WEST SUSSEX COUNTY COUNCIL CONSULTATION

TO:	Arun District Council FAO: Jonny Cooper
FROM:	WSSC – Highways Authority
DATE:	2 April 2026
LOCATION:	270 Chichester Road Bersted PO21 5AX
SUBJECT:	BE/10/26/HH Dropped kerb in front of the property.
DATE OF SITE VISIT:	n/a
RECOMMENDATION:	Advice

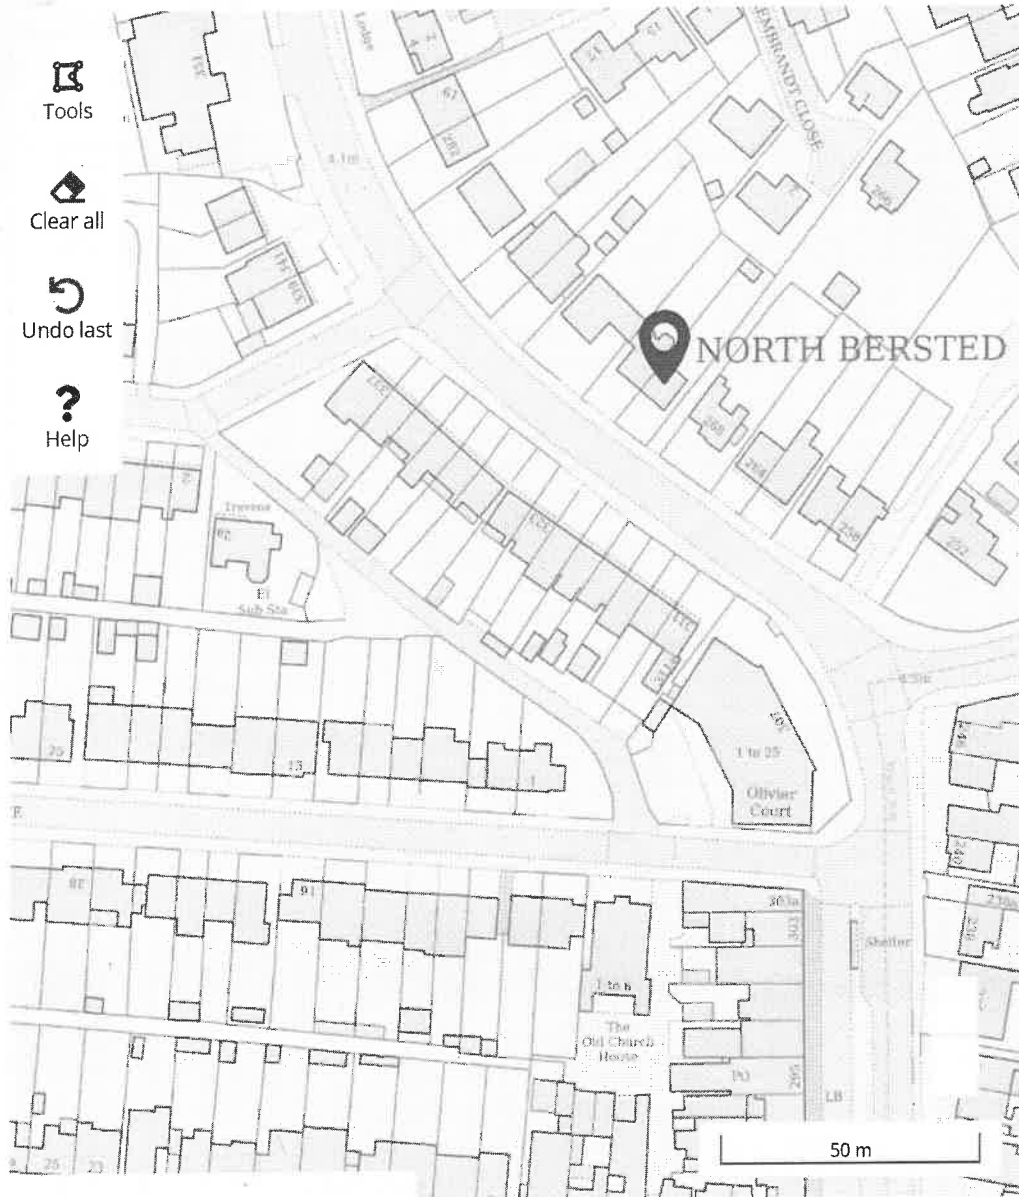
The proposed access will be 5.57m in width and will provide access to one parking space on the existing driveway. The access works are subject to a licence from the WSSC Area Engineer and must be constructed to a specification agreed with them.

Visibility at the proposed access appears to be sufficient for the anticipated road speeds in this location and splays appear to be maintainable wholly within the public highway.

The use of the access shall not commence until such time that it has been constructed in accordance with the details shown on the drawing titled Detailed Plan.
